SITE DATA:

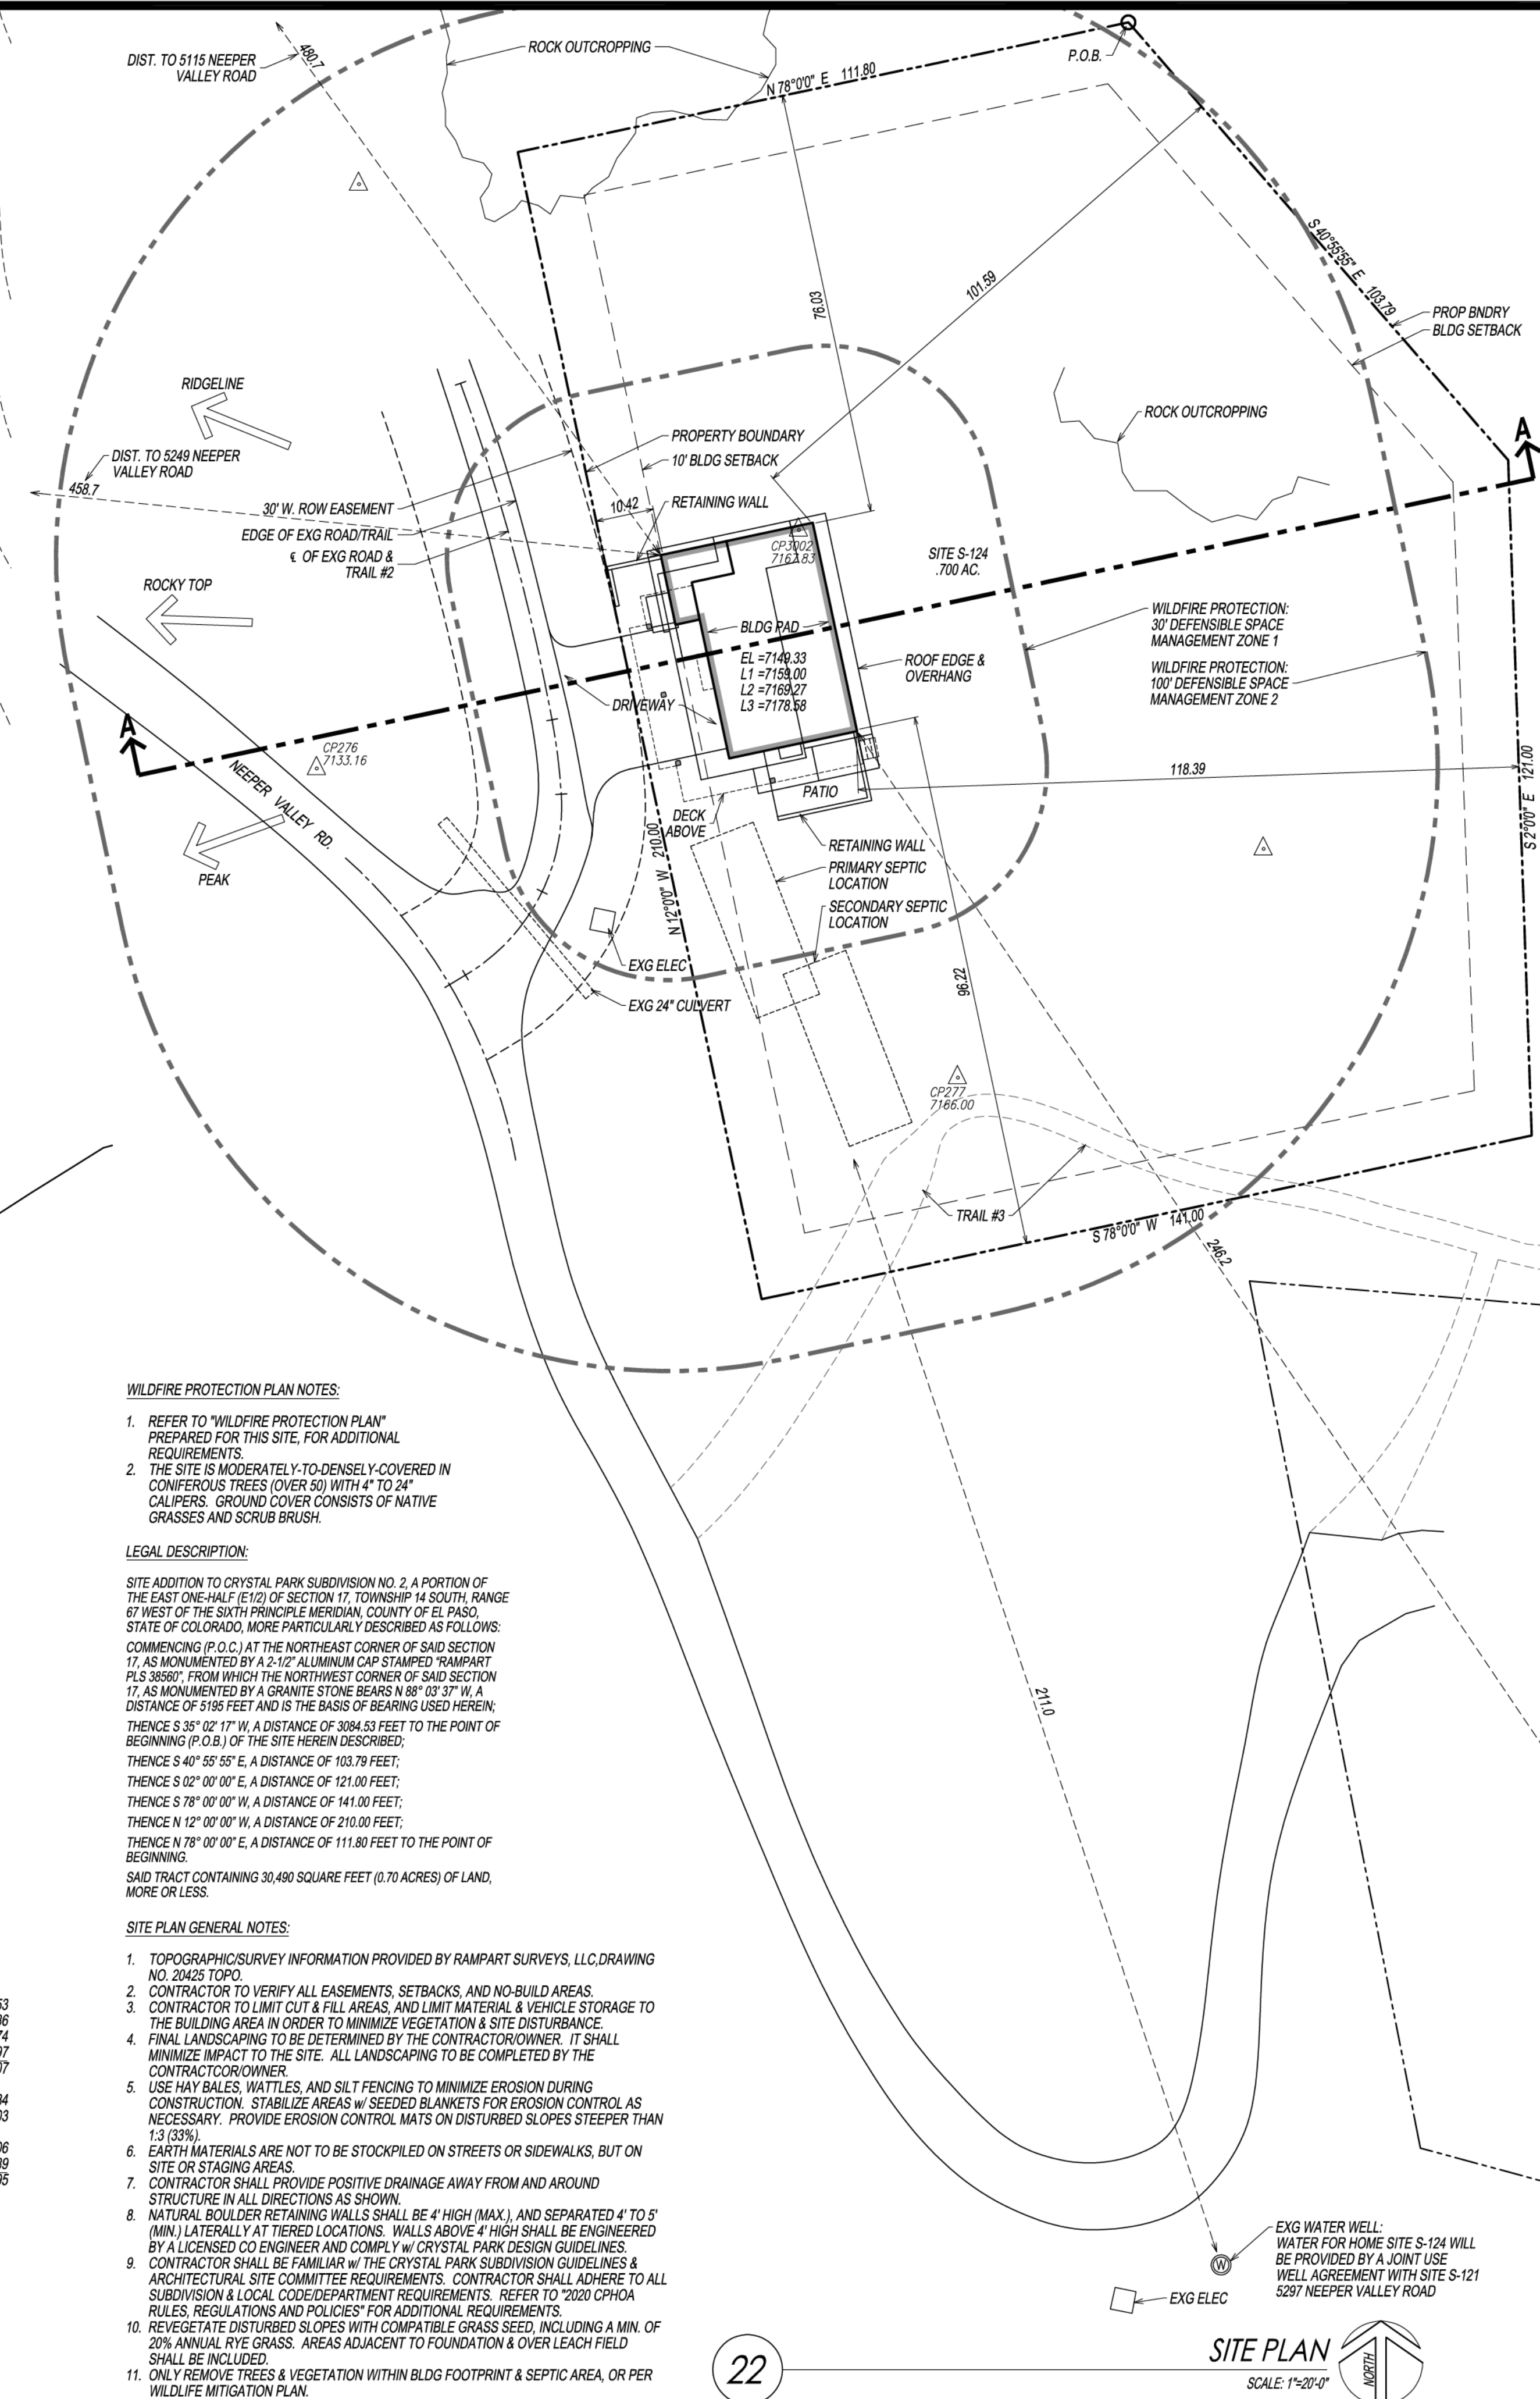
Please revise / add notes per comment from Colorado Geologic Survey (on EDARP), as well as per the recommendations within the soils & geology report submitted.
